**Your Ref: 2025/1062
Our Ref: B/00341**

Land adjacent to 1A West Street, Worsbrough Bridge, Barnsley - (BARN) Demolition of existing domestic garage and formation of new driveway/parking, and outline permission for the erection of 4 houses within the residential garden

SITE PLAN
SCALE 1:250

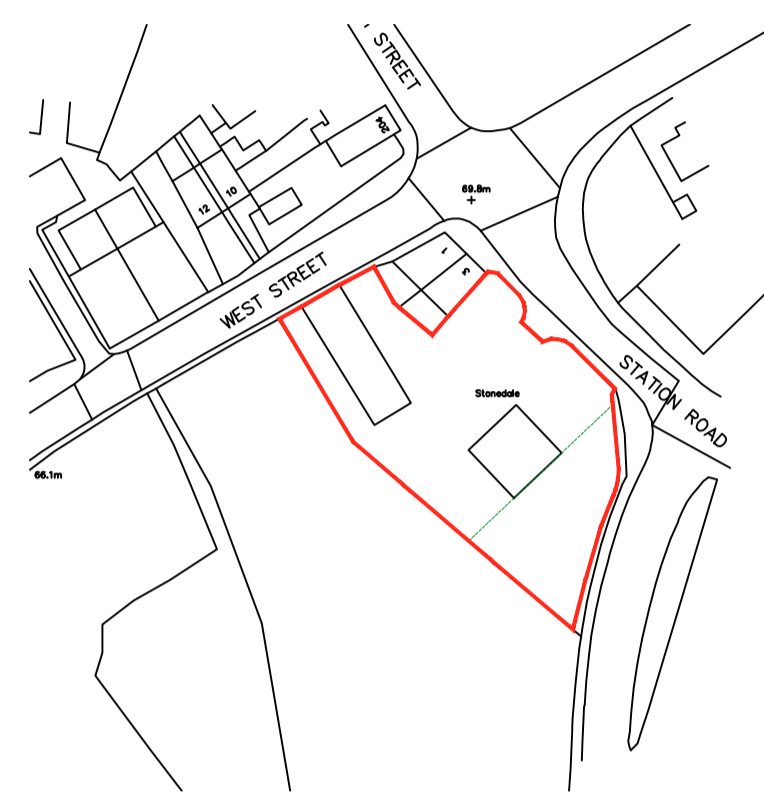
Yorkshire Water objects to the application due to lack of submitted proposed drainage.

- 1.) The developer is proposing to discharge surface water to SUDS but the eventual outfall has not been stated. sustainable development requires appropriate surface water disposal.
 - a.) Yorkshire Water promote the surface water disposal hierarchy and the developer must provide evidence to demonstrate that surface water disposal via infiltration or watercourse are not reasonably practical before considering disposal to public sewer.
 - b.) The developer and LPA are strongly advised to seek comments on surface water disposal from other drainage bodies as further restrictions may be imposed.

c.) As a last resort, and upon receipt of satisfactory evidence to confirm the reasons for rejection of other methods of surface water disposal, curtilage surface water may discharge to public surface water sewer. Surface water discharges to the public sewer must have a minimum of 30% reduction based on the existing peak discharge rate during a 1 in 1 year storm event.

d.) The developer will be required to provide evidence of existing positive drainage to a public sewer from the site to the satisfaction of Yorkshire Water and the Local Planning Authority by means of physical investigation. On-site attenuation, taking into account climate change, will be required before any discharge to the public sewer network is permitted.
